Arun District Council
Arun Civic Centre
Maltravers Road
Littlehampton
West Sussex BN17 5LF
Planning & Building Control General Enquiries
Tel: (01903) 737756 Fax: (01903) 730442
Dx: 57406 Littlehampton
Minicom: 01903 732765
e-mail: planning@arun.gov.uk
website: www.arun.gov.uk/planning

Application No: AL/44/22/HH
Site Address: Norton Farm House Norton Lane Norton PO20 3NH
Description of works: Installation of glazed link to garage and alterations to existing fenestration/openings. (This application may affect the character and appearance of the Norton Lane, Norton Conservation Area and a Listed Building.)

Thank you for your internet representation made on 12th May 2022 which has been recorded as an objection with the comments as follows:

Stage	Planning
Project	Norton Conversion
Client	Open Design Studio
Drawing No.	2206-00-200
Title	Pr Elevations 01 & 02
Scale	1:100
Drawn	JRB

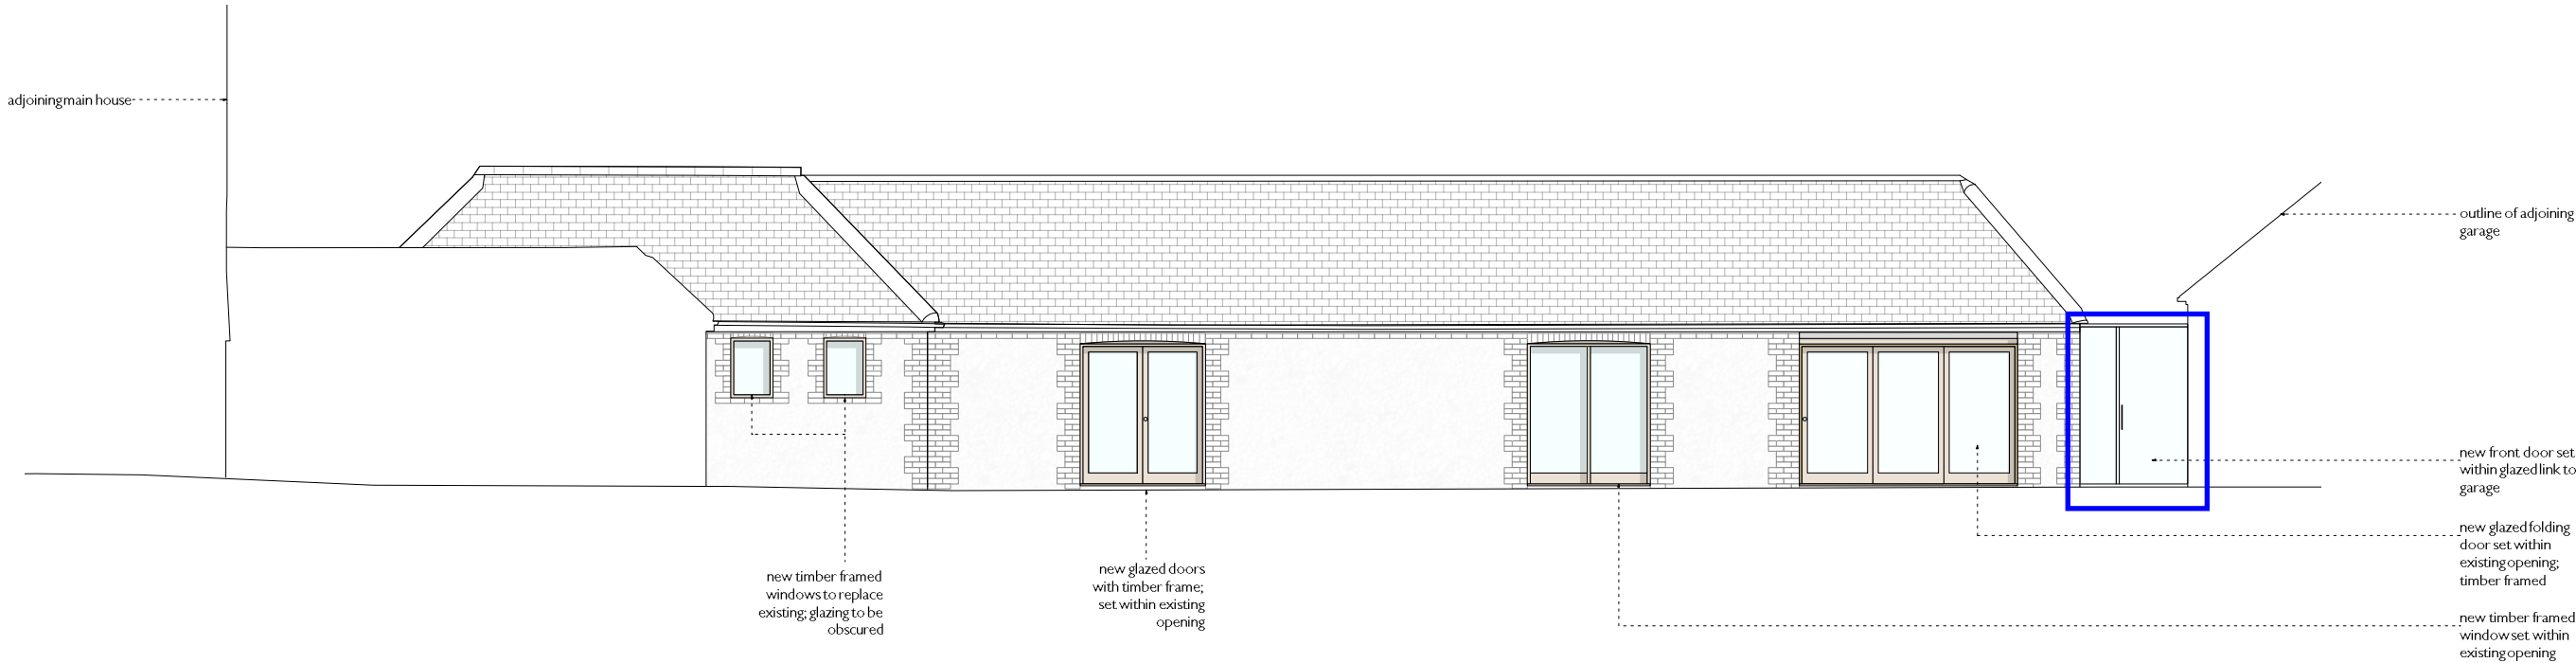
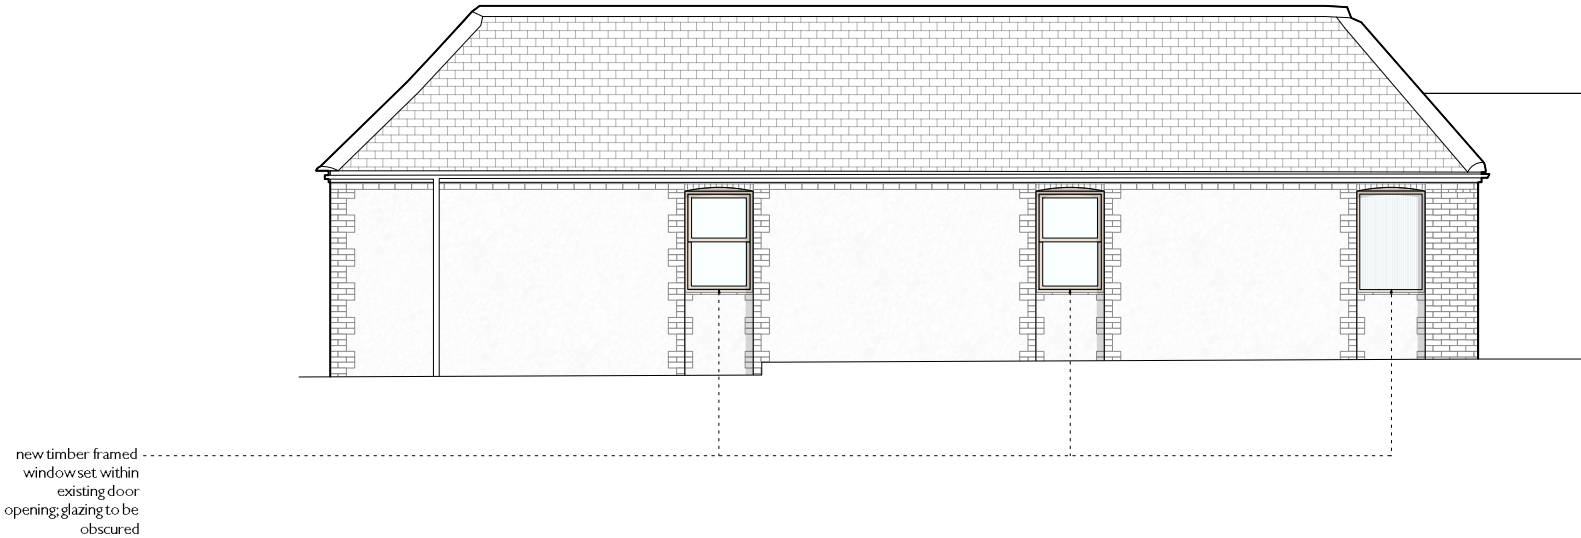
The Parish Council has objected to this on several occasions under previous applications. This development is out of character within the setting of a listed building, and is overdevelopment of the site (ANDP H3, EH8, & EE7). The roof light design also impacts on dark skies area (EH10). This is not an extension of the building but a new development in its own right and is linked to a building that is subject to enforcement by ADC. The alterations to existing fenestrations/openings are not in keeping with the character of the building.
